KIRKLEES METROPOLITAN COUNCIL INVESTMENT & REGENERATION SERVICE

DELEGATED DECISION TO DETERMINE PLANNING APPLICATIONS

Reference No:	2025/62/93523/W
Site Address:	23, Moor Park Avenue, Beaumont Park, Huddersfield, HD4 7AL
Description:	Erection of two storey side and rear extensions and front porch, alterations to roof including increasing height of eaves and associated works
Recommending Officer:	Joanna Rednall

DECISION – Conditional Full Permission

Drawing Title:
Proposed Grouped Plans

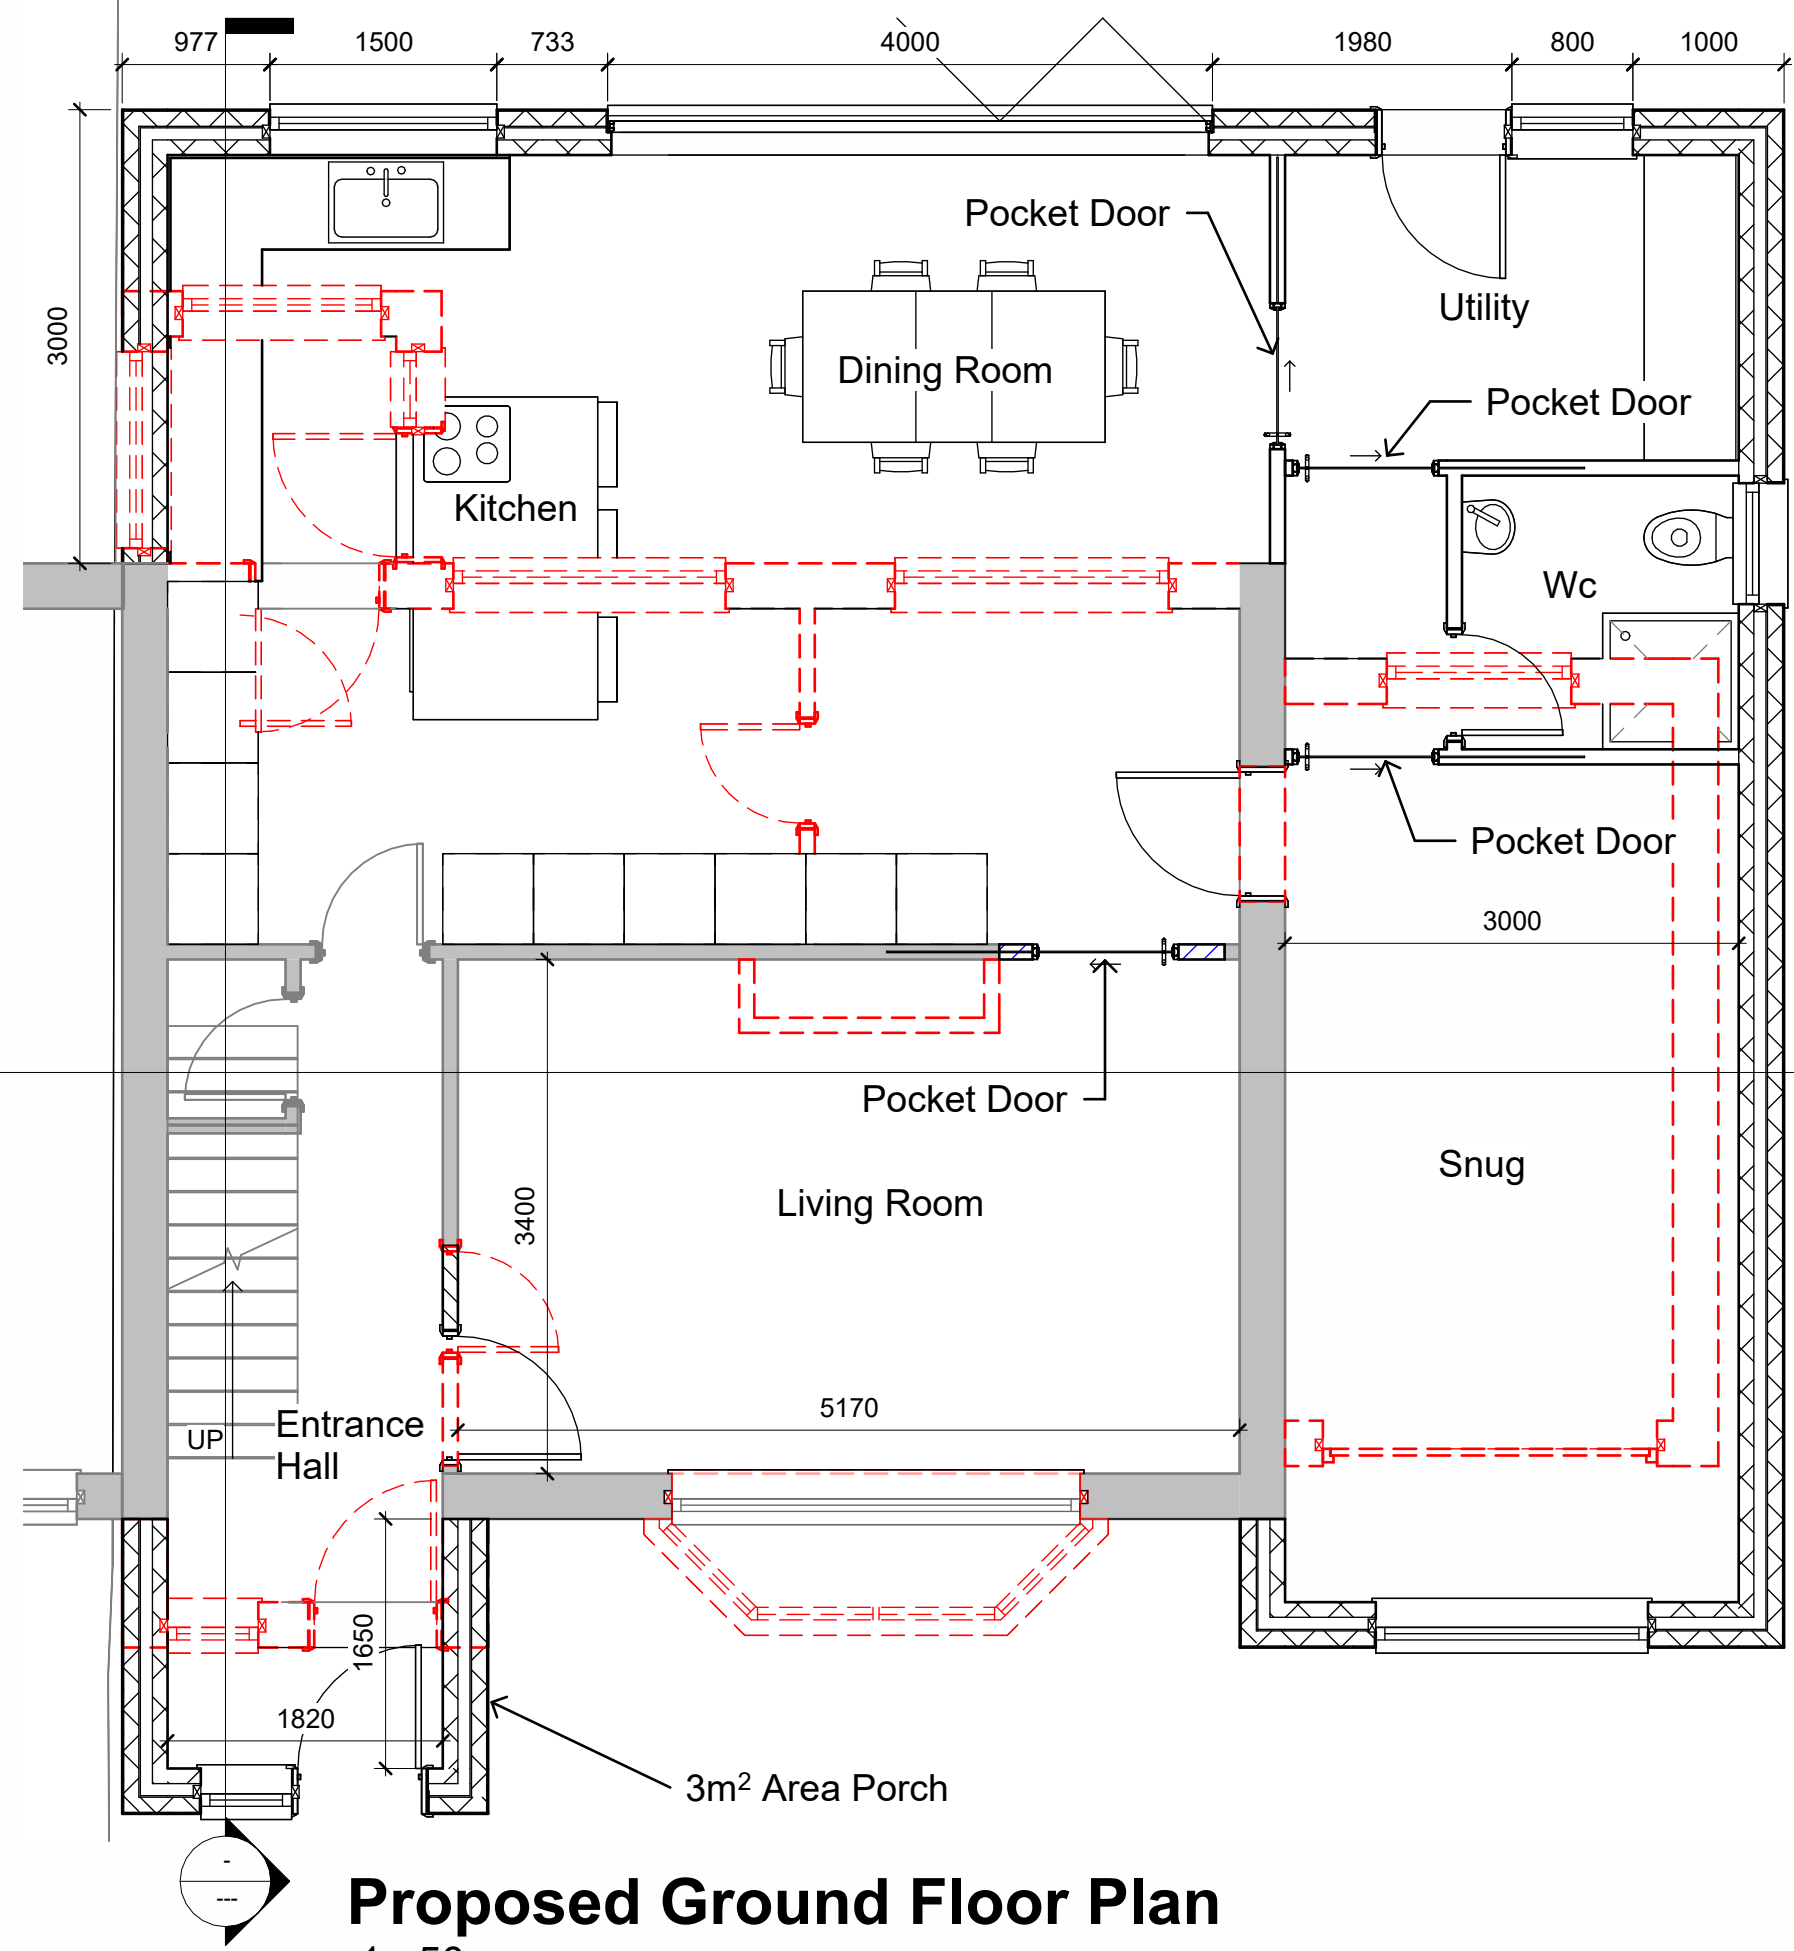
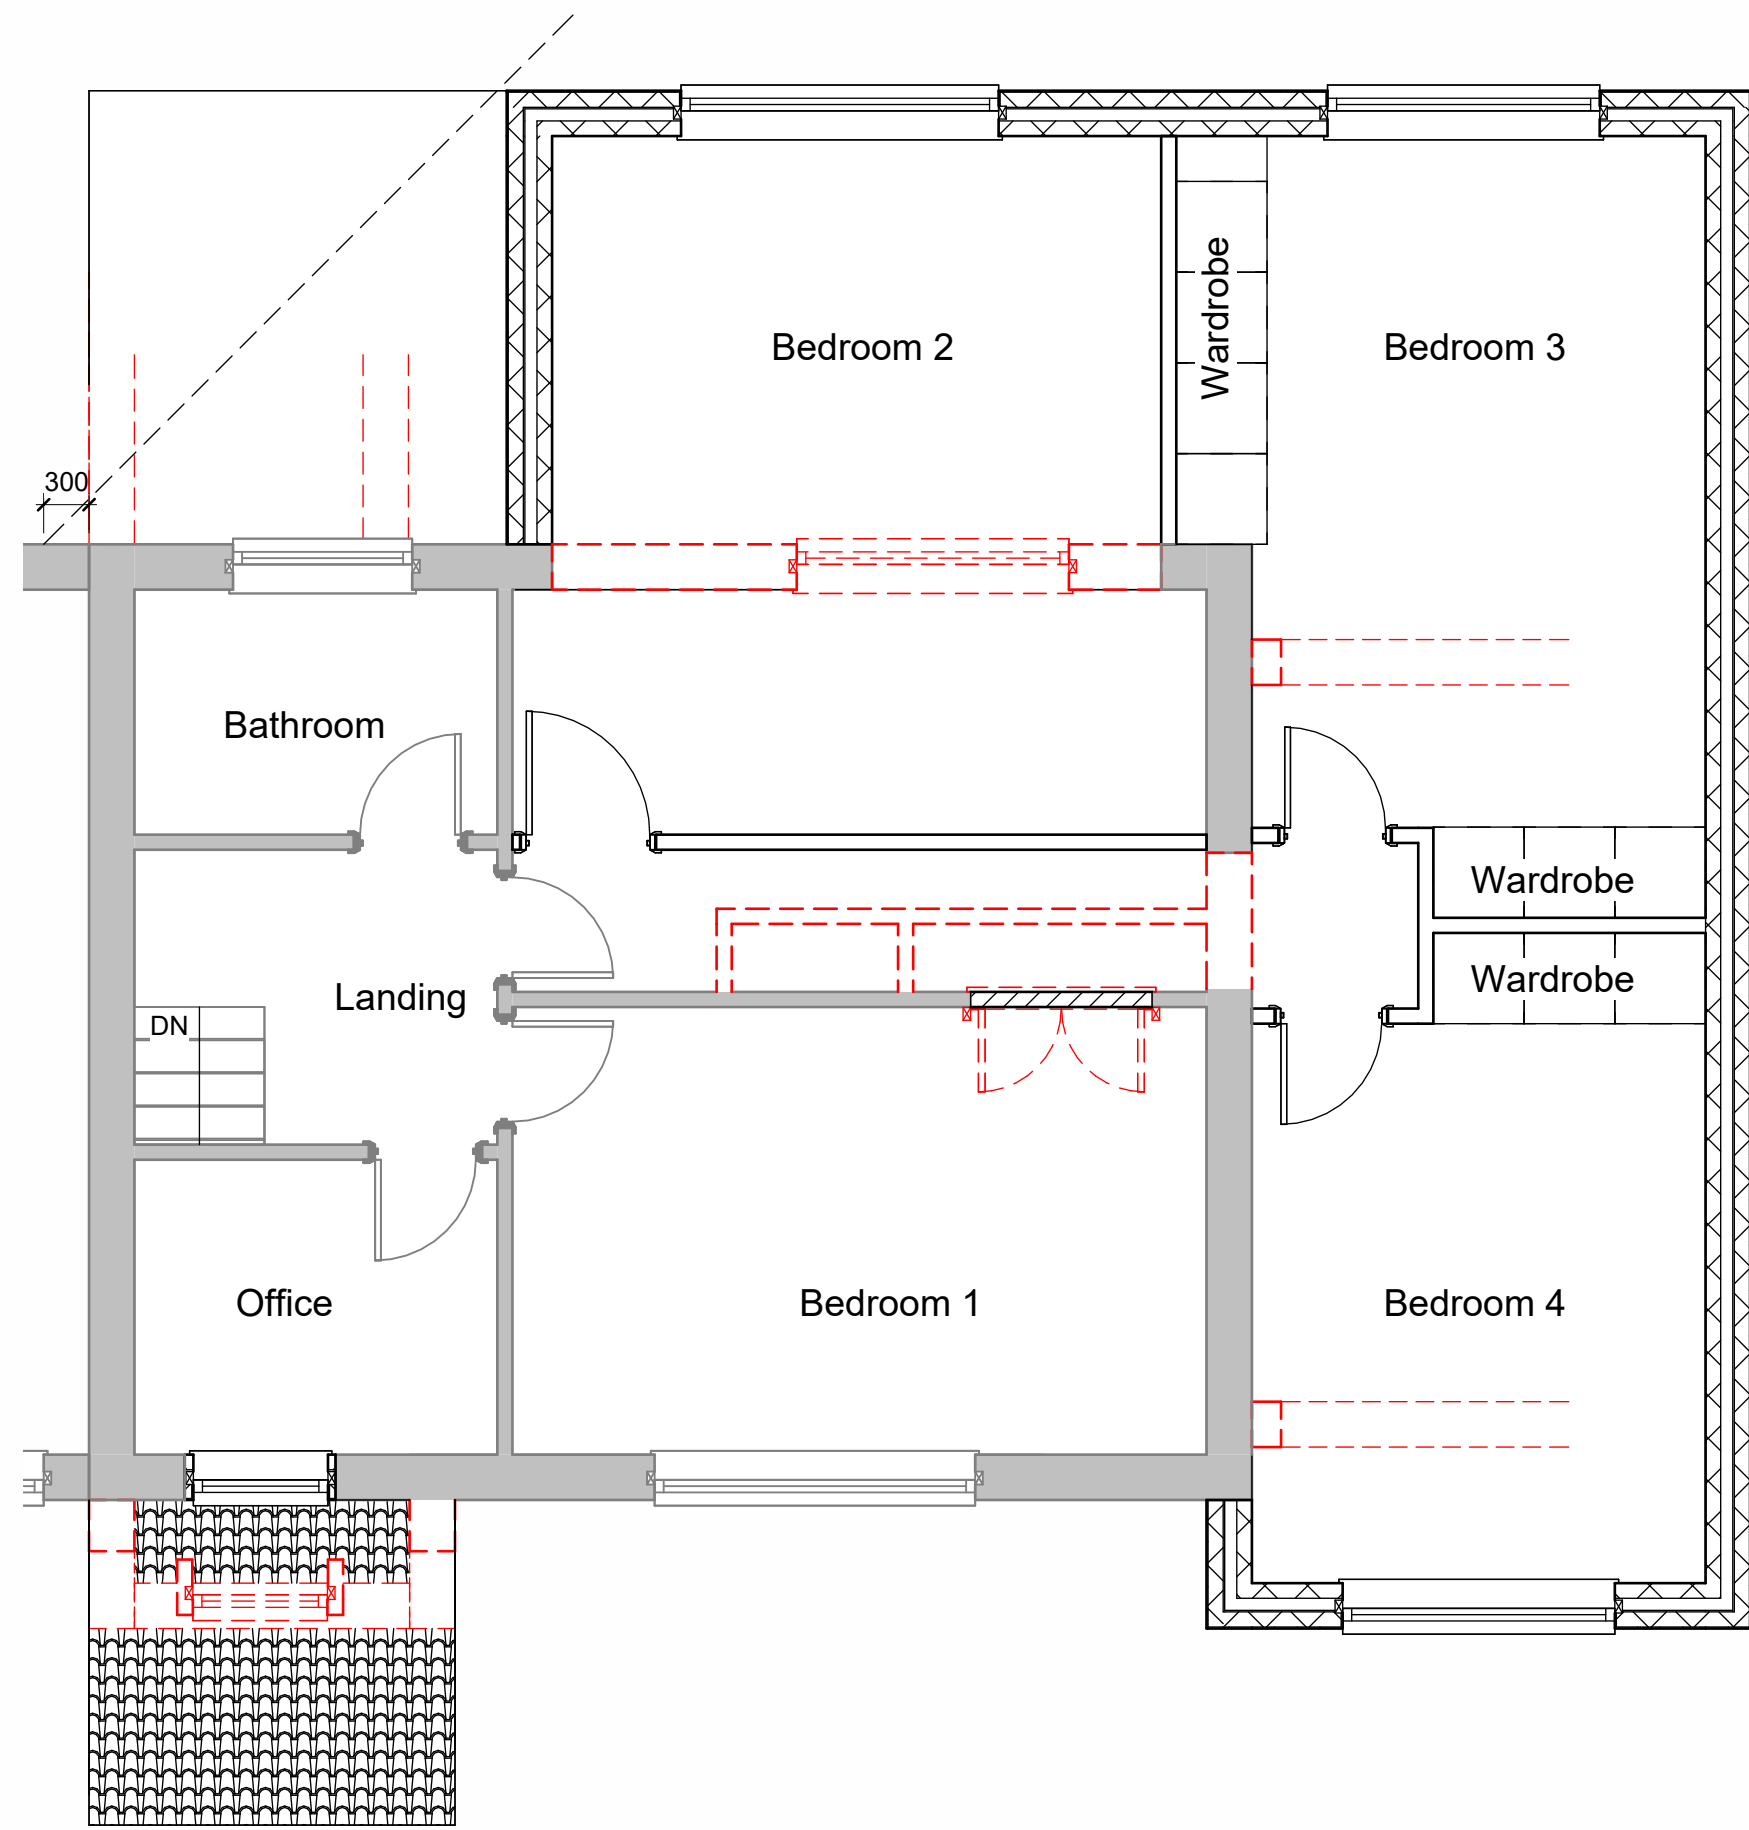
With regard to privacy, the submitted plans indicate that a single window is proposed within the side elevation at ground floor level, alongside glazing to the front and rear elevations at both ground and first floor levels. The ground floor side window would serve a WC and would face existing boundary treatments and the detached garage associated with 25 Moor Park Avenue, thereby limiting any potential for overlooking.

Turning to the rear extensions, these would extend up to the common boundary with No. 21, with a separation of approximately 0.3 metres at ground floor level and 3 metres at first floor level. The submitted plans demonstrate that a 45-degree line, when taken from the shared boundary, would be maintained in relation to the two-storey element. As such, this element is not considered to result in an unacceptable loss of light or outlook to the occupants of No. 21. While the plans do not explicitly demonstrate compliance with a 45-degree line when taken from the centre of the closest window in respect of the single-storey rear extension, officers note that this element would be limited in height to approximately 2.8 metres and would project only 3 metres from the rear elevation. Given its modest scale and single-storey form, any associated loss of light would be minor and would not be detrimental to neighbouring living conditions.

The proposal would increase the number of bedrooms in the dwelling from three to four. The Council's SPD recommends that a four-bedroom dwelling should be provided with three off-street parking spaces. Although the development would result in the loss of the internal garage, the existing front driveway would be retained and is sufficiently large to accommodate off-street parking for the dwelling.
